Subject: B7 Design Review – Bayside Bowl Addition

Written by: Caitlin Cameron, Urban Designer

Date of Review: Friday, May 29, 2015

Title:
 PLANTING PLAN

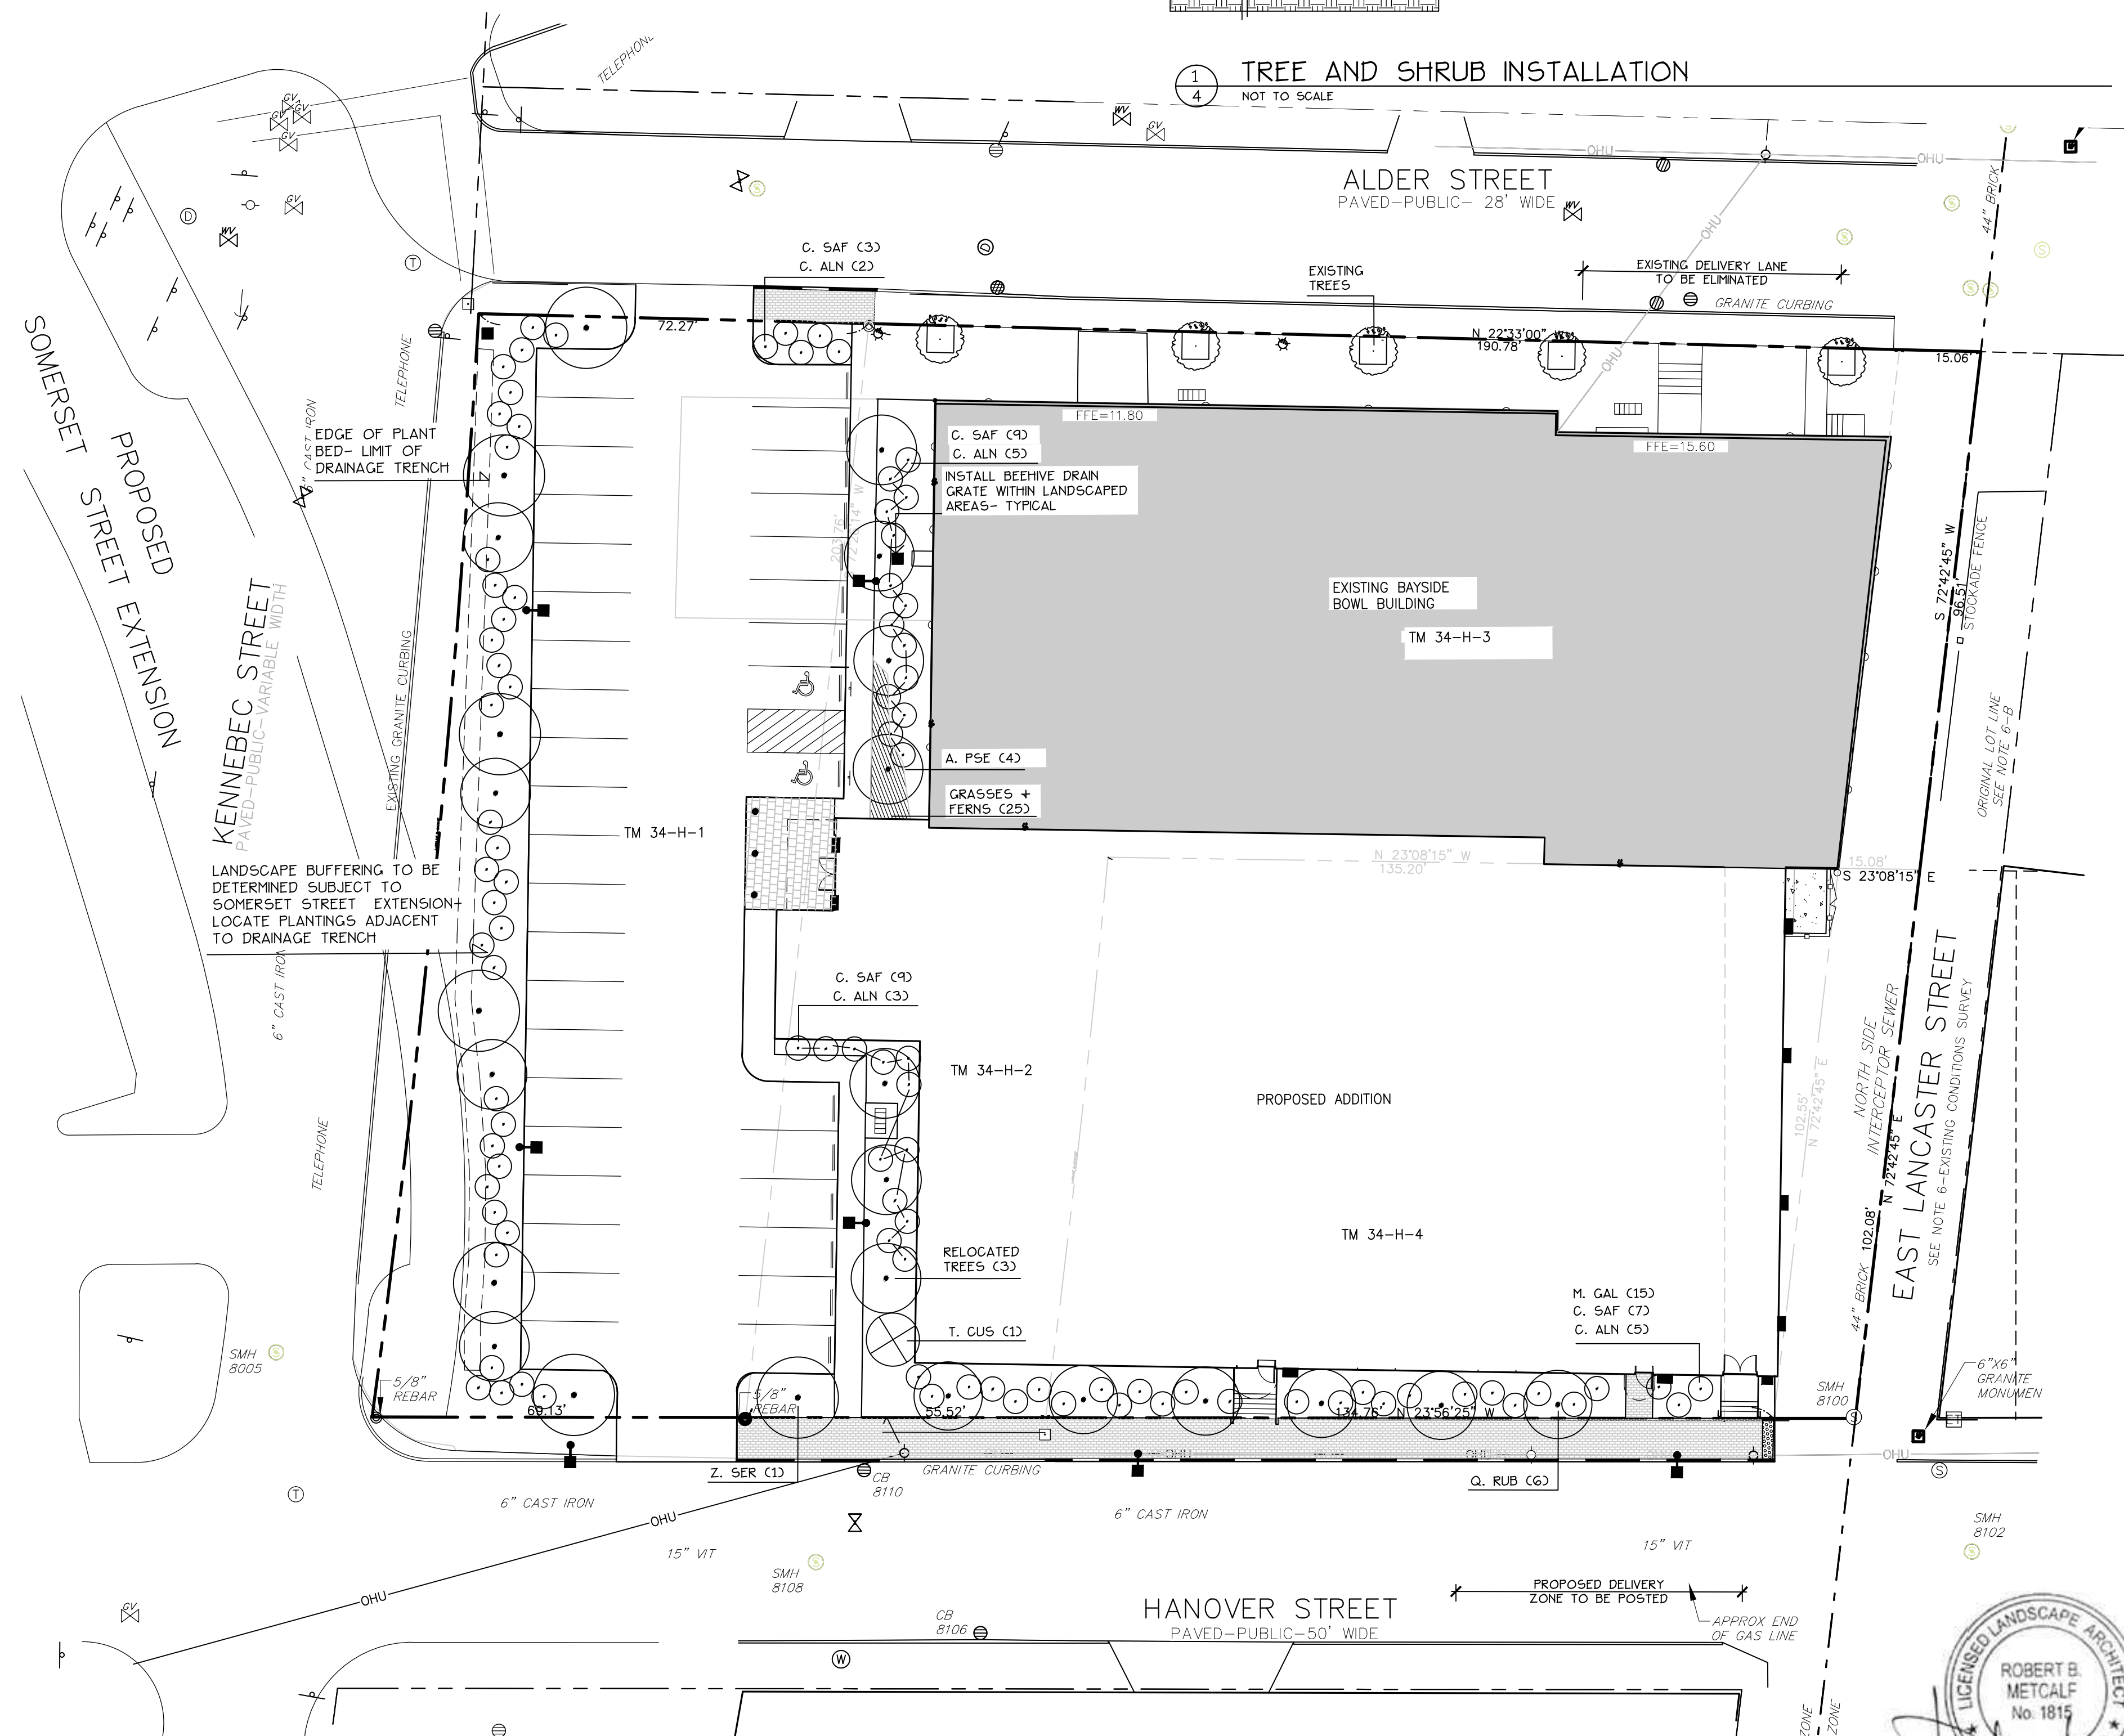
- **The Planning Board feels the sidewalks as proposed are adequate and meet the requirement.**

- **The Planning Board feels the sidewalks as proposed are adequate and meet the requirement.**

- **Bike racks appear to be on private property. If any bike racks are proposed in the public right-of-way, they must conform to the Technical Manual in placement as well as type specification (Dero).**
